# CITY OF ALBUQUERQUE

June 5, 2014

RE: **Mirabal Residence**  
**Grading and Drainage Plan**  
**Engineers Stamp Date 5/08/14 (D10-D003B1)**

ENGINEER'S SEAL  6/6/14 DAVID SOULE P.E. #14522	LOT 15, BLOCK 6, UNIT 22 VOLCANO CLIFFS SUBDIVISION MIRABAL RESIDENCE	DRAWN BY JDG DATE 05-08-2014
	GRADING AND DRAINAGE PLAN  Rio Grande Engineering 1606 CENTRAL AVENUE SE SUITE 201 ALBUQUERQUE, NM 87106 (505) 872-0999	SHEET # 1 OF 1 JOB #

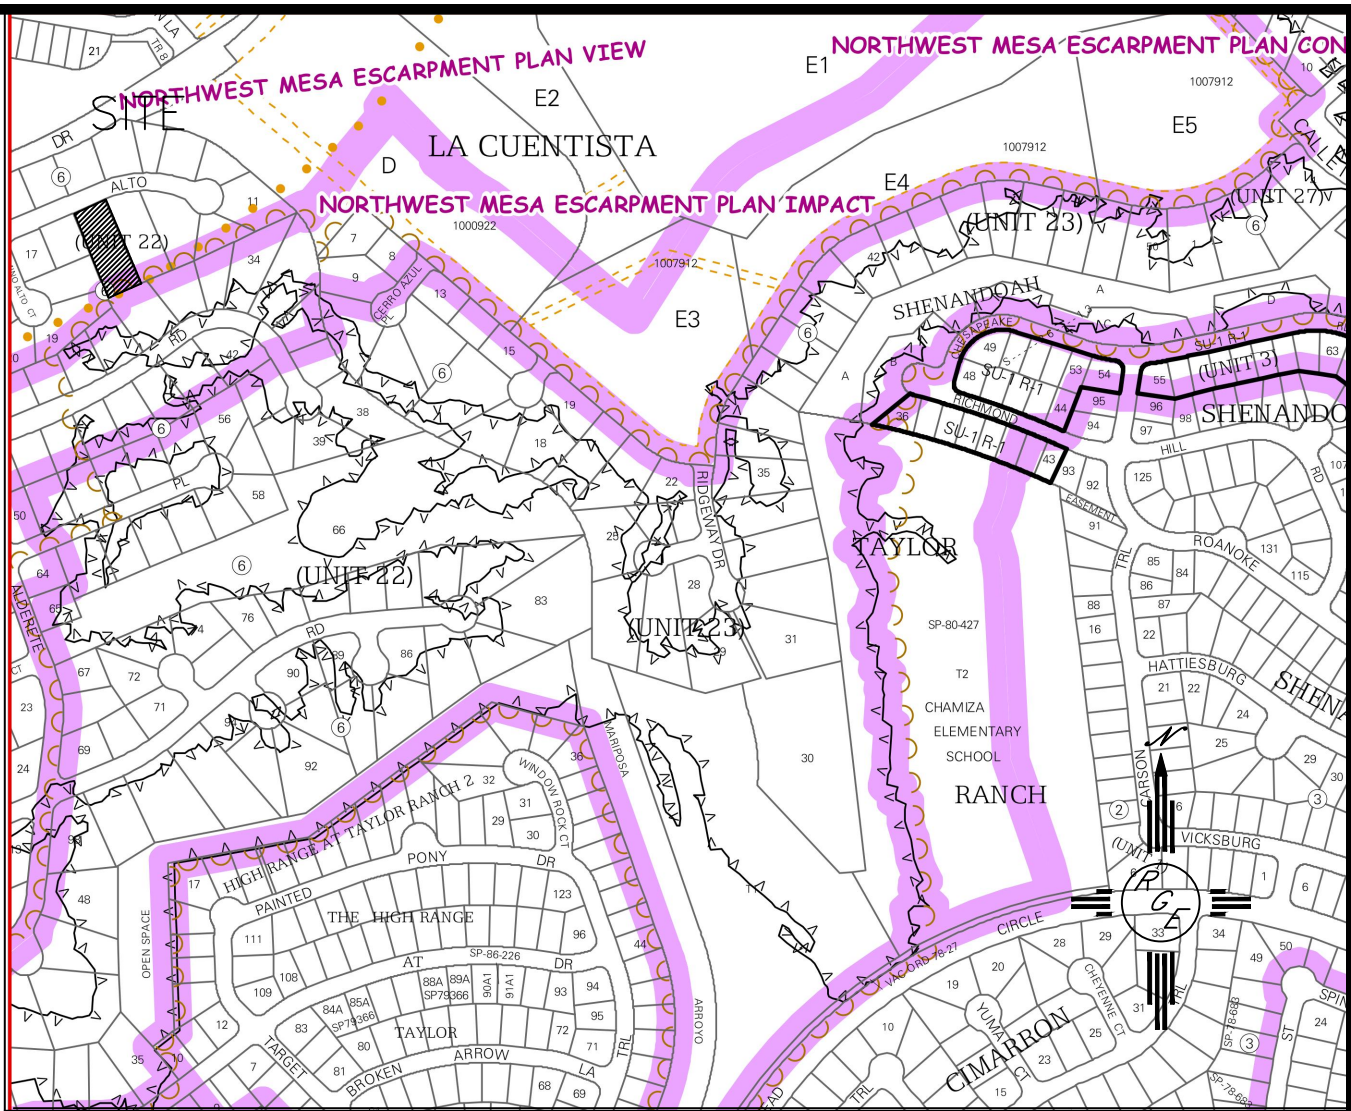
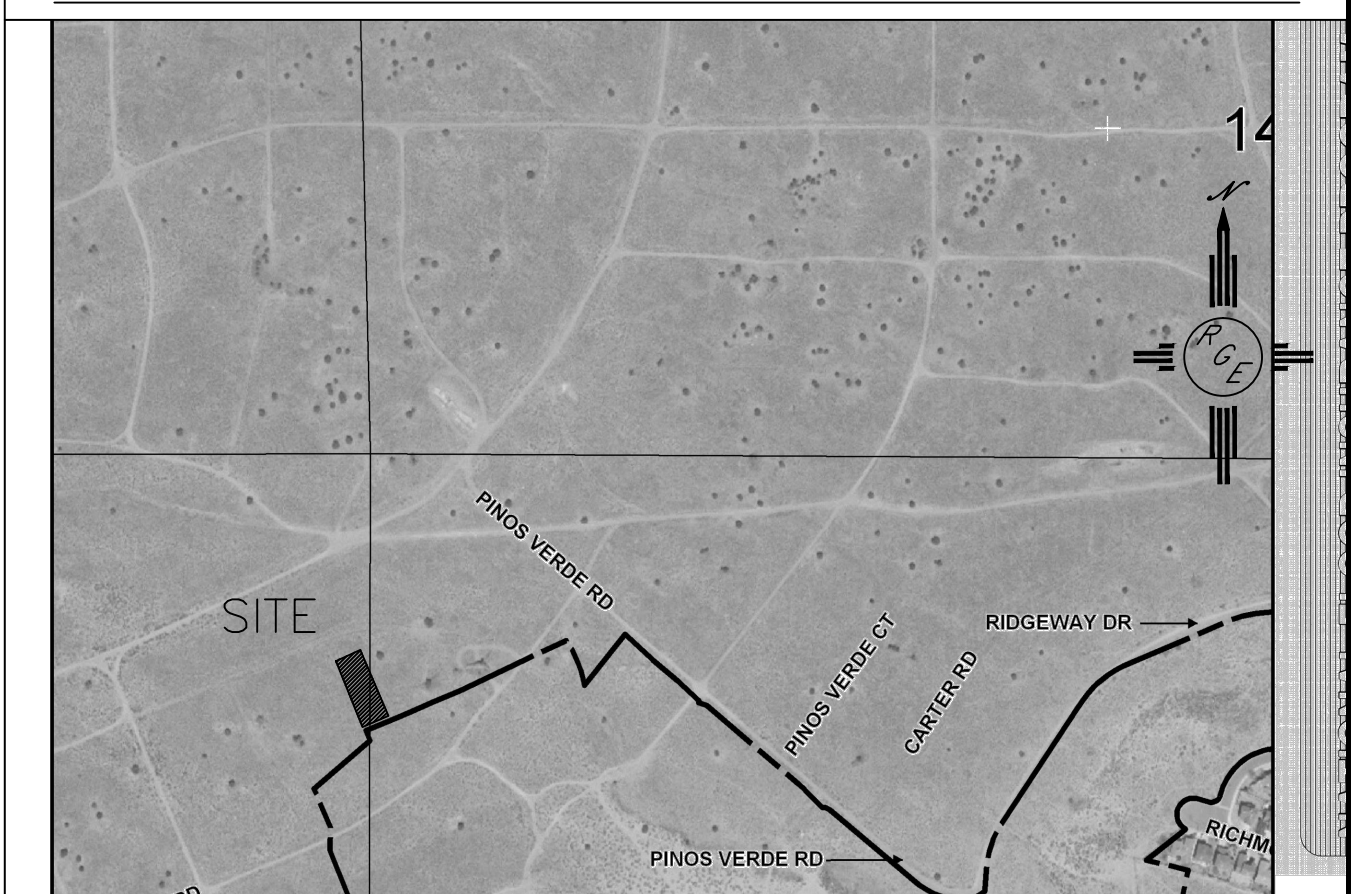
- The ponds and infrastructure need to be certified.
- There is one lot specified on the plans but four addresses given on the sheet. Is this lot being built for 4 homes?
- Build notes are needed.
- Label the proposed contours and differentiate between each contour in the legend.
- This lot is in two different basins. Quantify these flows for pond 7 since Basin 207 is allowed to free flow south.
- How is the remainder of basin 207, to the east of this lot, allowed to discharge? It appears that basin 207 will be blocked with the screen wall.
- The solid black line in the middle of the home, is this a retaining wall?
- Existing contours around the site are difficult to read.
- It appears that flows are headed towards the home in the middle of this site.
- Two elevation spots on the west of the driveway are 5305, they do not appear to be correct?
